APPLICANT'S RESPONSES TO RELEVANT REPRESENTATIONS AND ADDITIONAL SUBMISSIONS

Drax Bioenergy with Carbon Capture and Storage

Document Reference Number: 8.3

PINS Reference: EN010120

DRAWING NUMBER
 EN010120-PA-ES-6.2.18.1-Sheet3

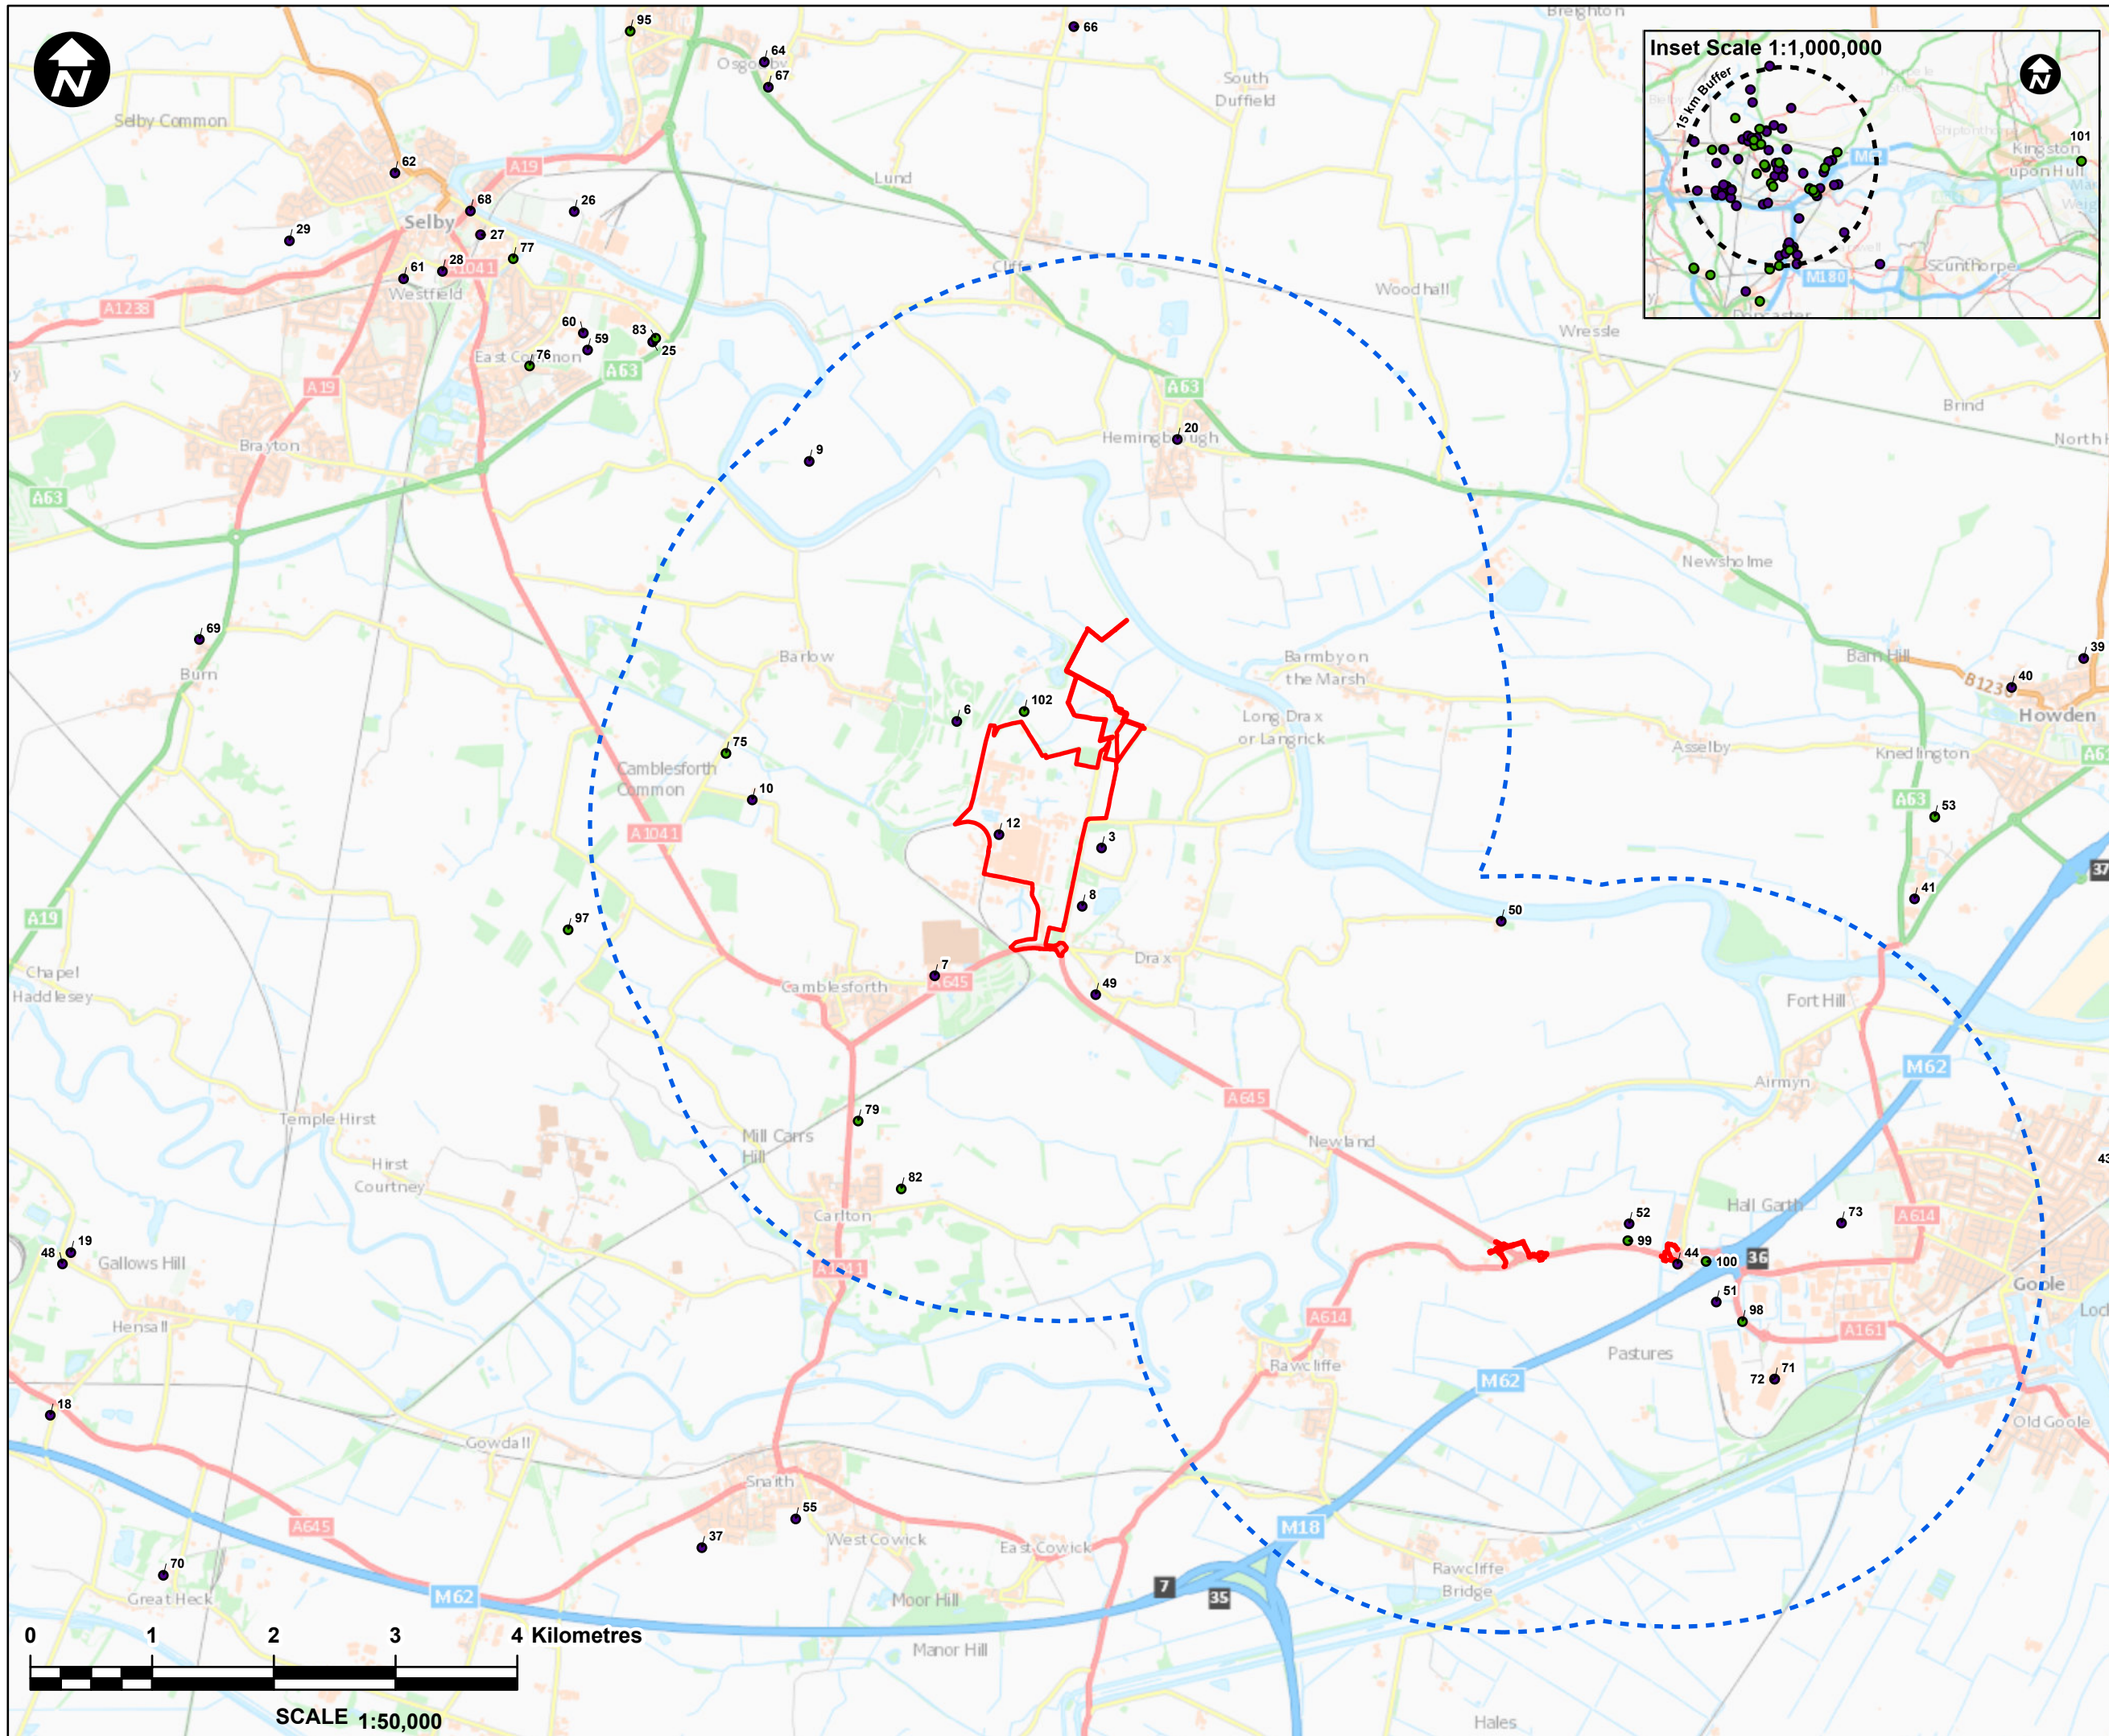
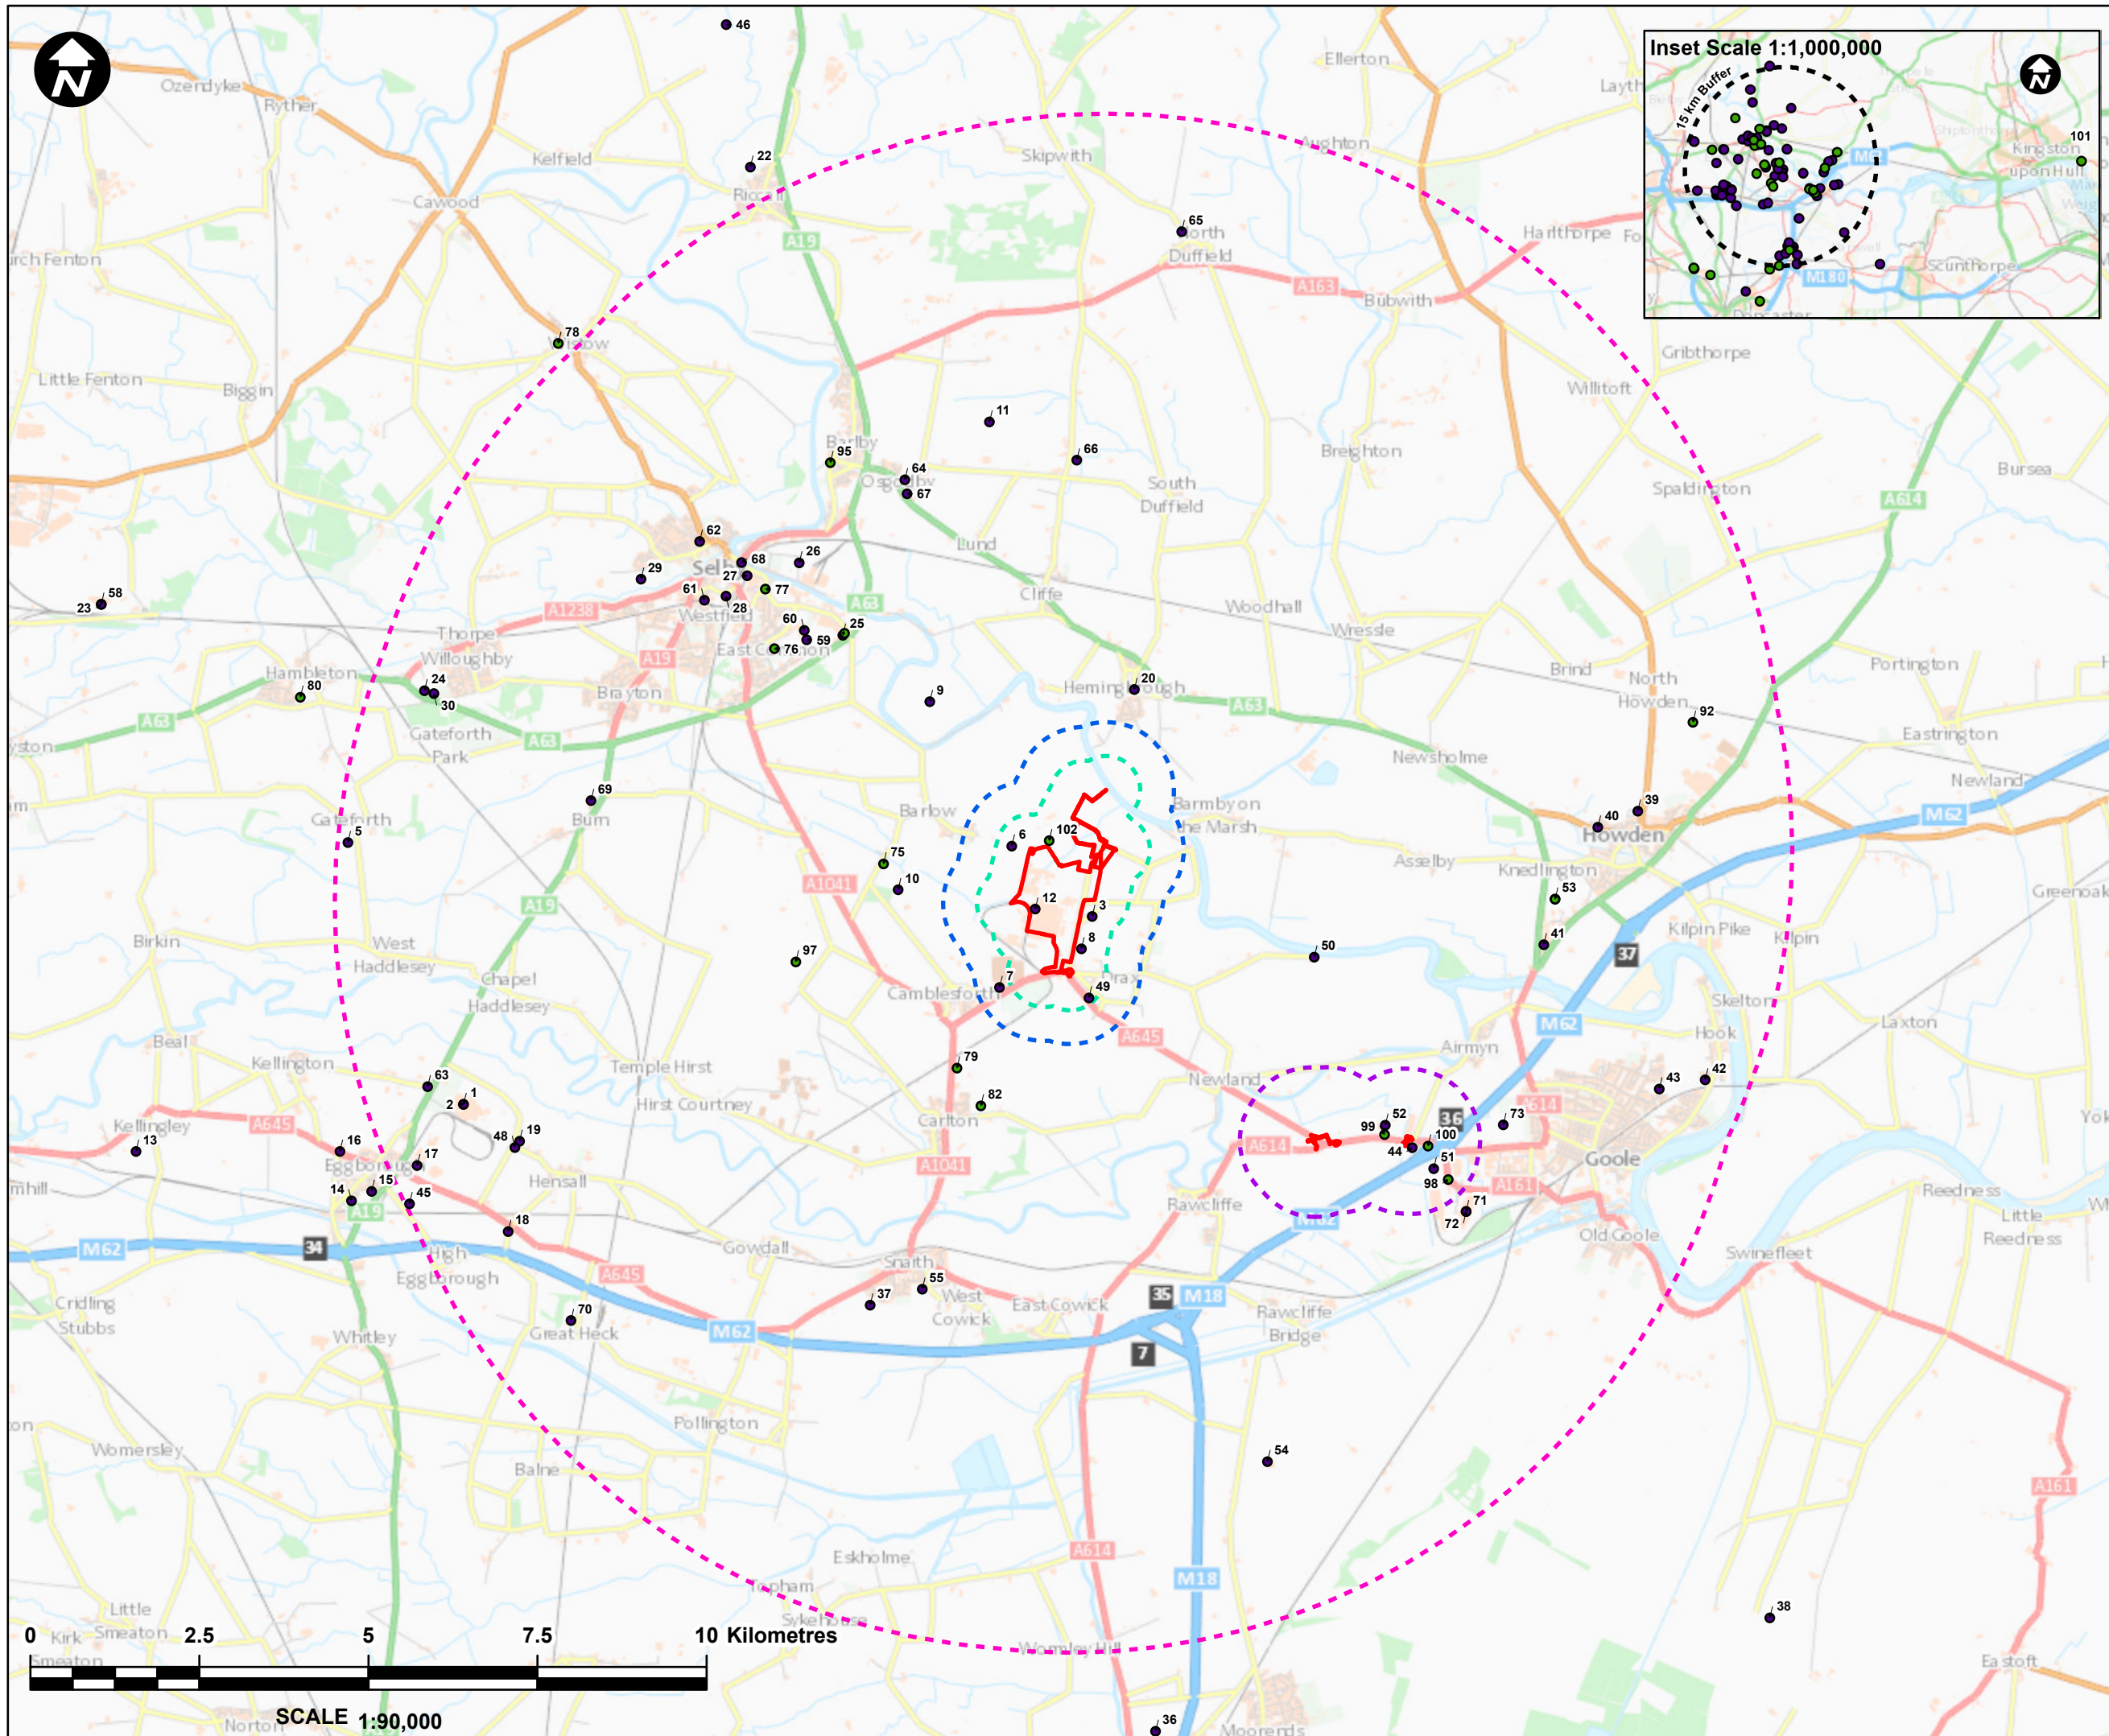
Response Ref.	Relevant Representation Comment	Applicant's Response
2.12. Cumulative	It has been noted that 6.3.18.2 Environmental Statement - Volume 3 - Appendix 18.2 'Short List of Other Developments' only contains 46 schemes, while the Environmental Statement refers to 76 schemes. It is understood that the applicant is aware of this issue and is looking to issue a corrected version for consideration.	This comment is noted and it is confirmed that the formatting error has been amended and a new version was issued to NYCC/SDC and other consultees on 1 September 2022. The updated document was reissued to PINS on 7 October 2022 (AS-013).
